From: Denise Galle <DGalle@tweed.nsw.gov.au>
Sent: Tuesday, 31 July 2012 12:00 PM
To: Jenny (on behalf of Darryl); shaunnicholson@newland.com.au; Stuart Campbell; Thomas FitzGerald
Cc: Patrick Knight; Danny Rose; Vince Connell; Joshua Townsend; Jonathan Lynch
Subject: Additional Clarification Landforming Area E - Altitude Aspire July 2012 (DA09/0701)

In response to your various e-mails Council would like to further clarify its letter of 20 July 2012 as follows:

A. Landforming

PLAN SHOWING
PROPOSED SUBDIVISION LAYOUT
& DESIGN CONTOURS

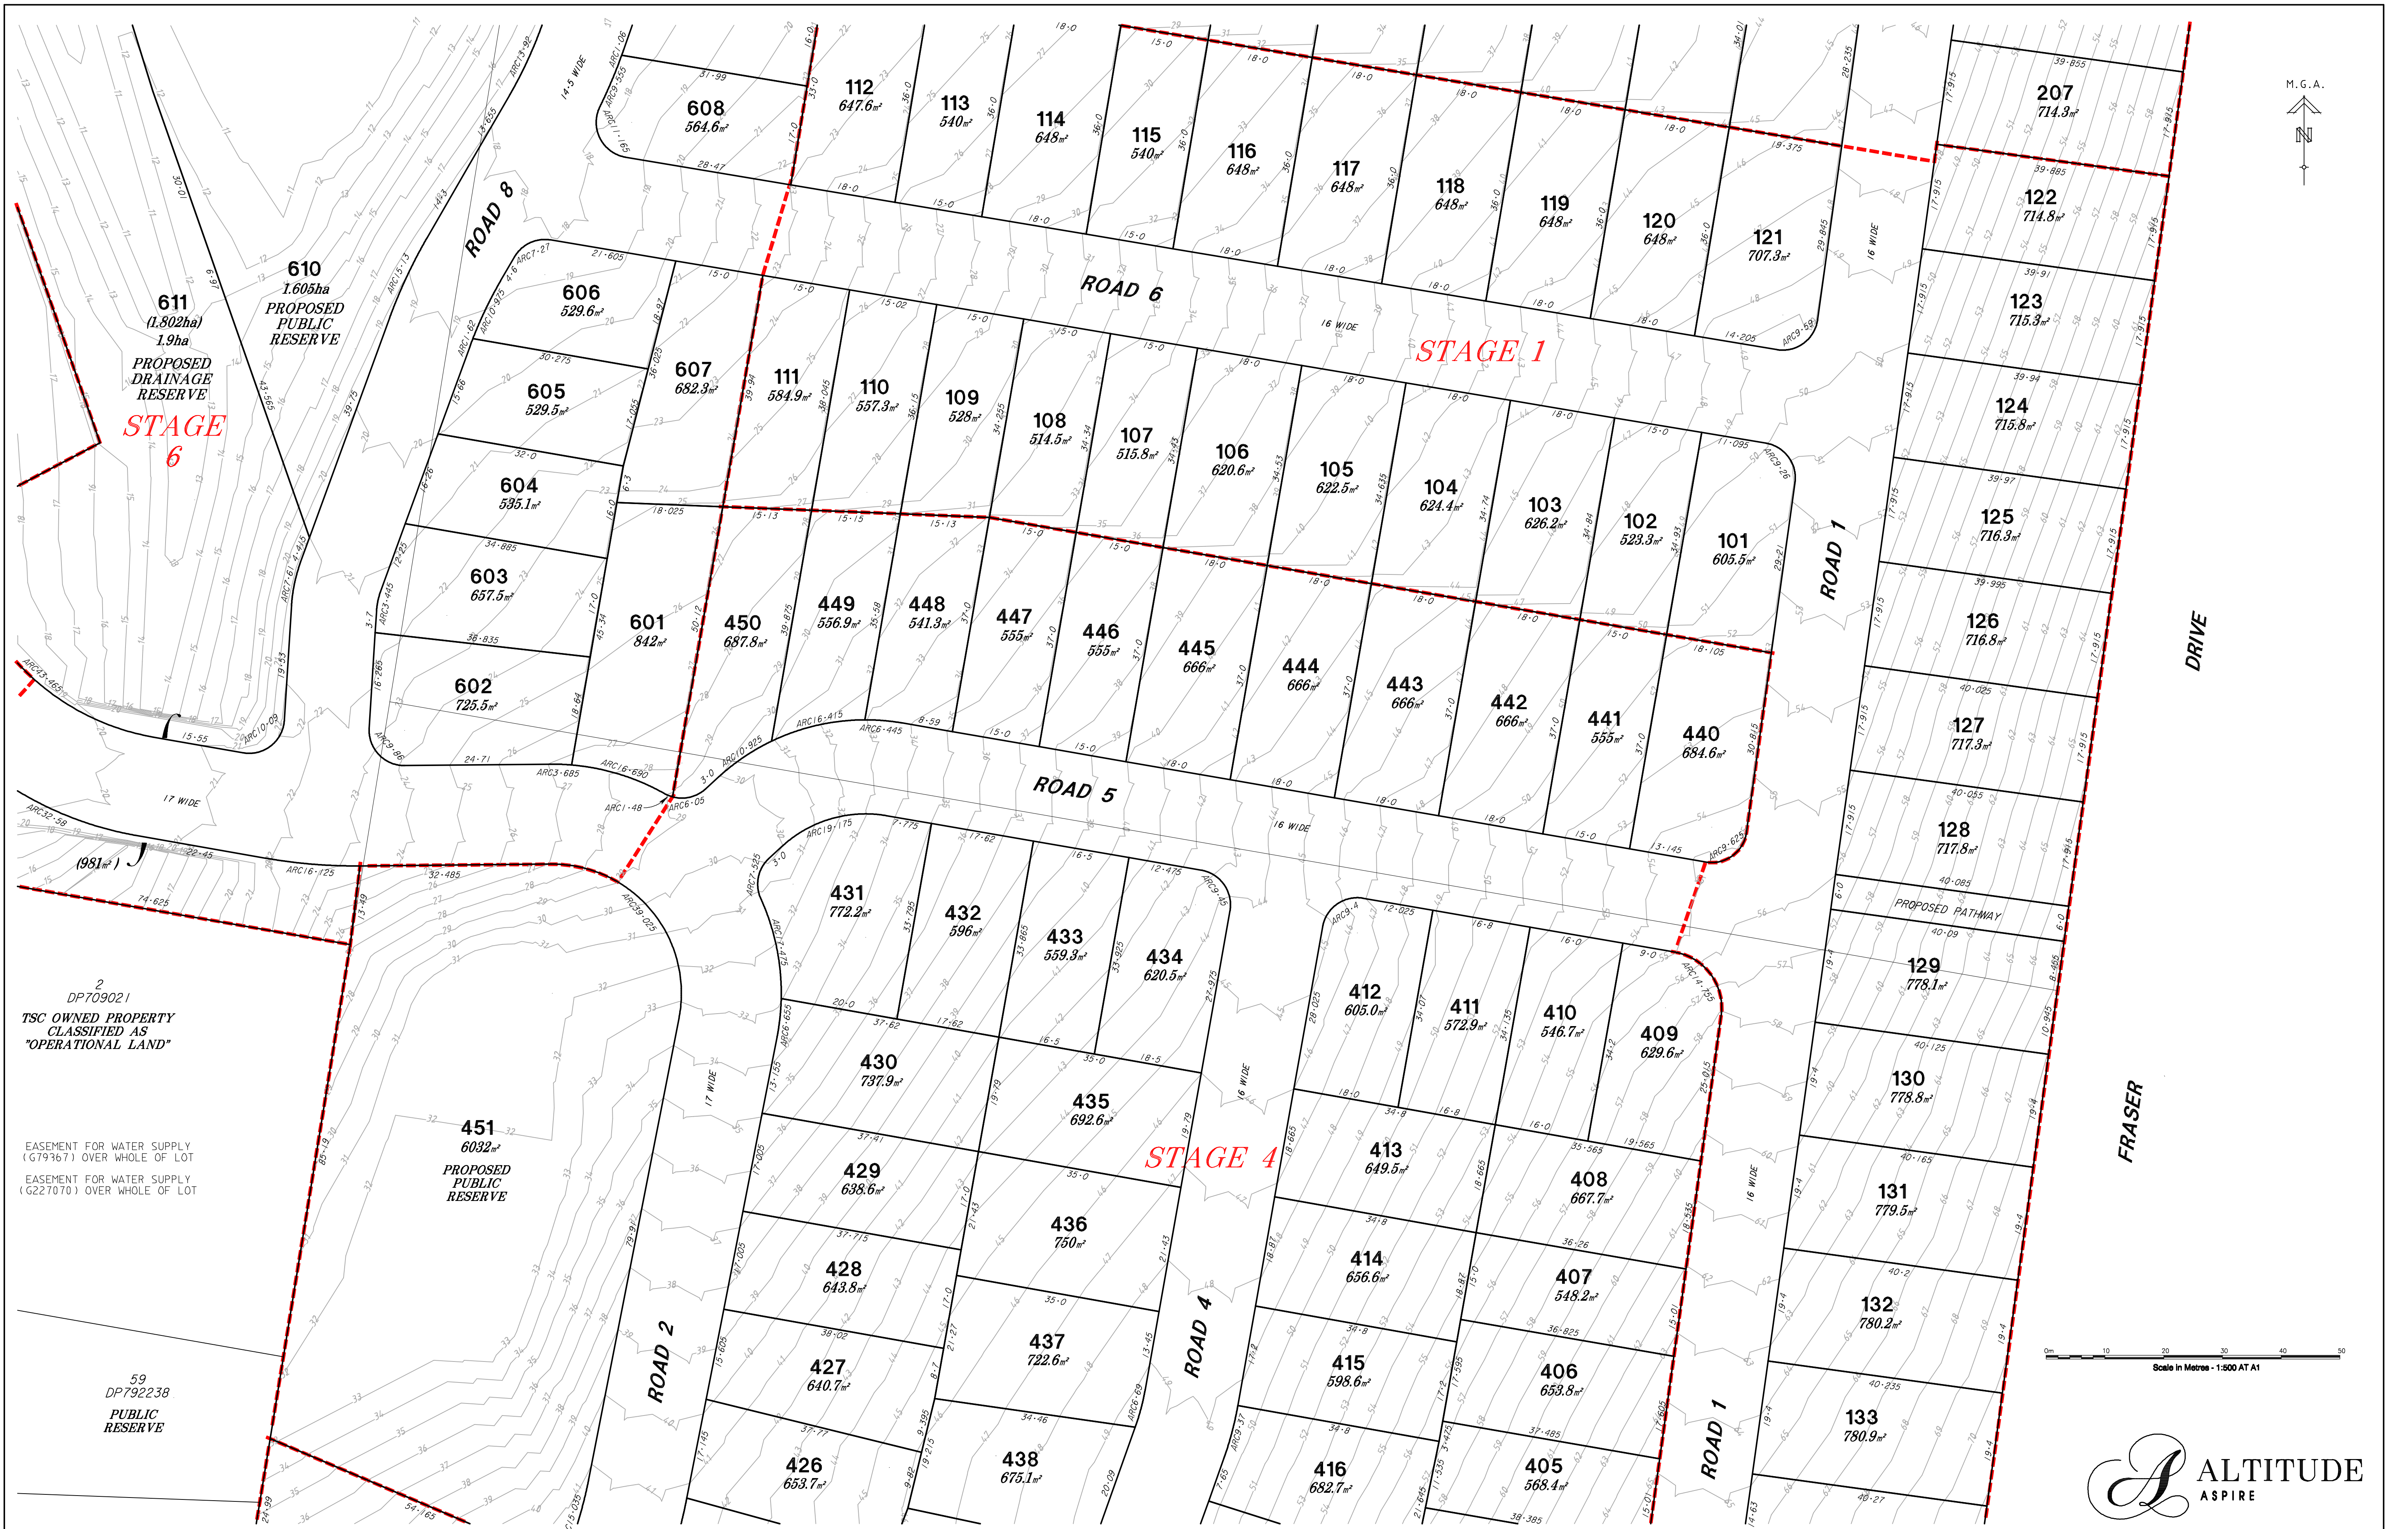
- Council staff would have some concerns with the contour lines shown over the amended plans as these still show significant level changes at the property boundaries, however, Newlands have advised me that these contours are outdated as detailed engineering work has not been undertaken to show the proposed finished ground levels which would comply with A5.
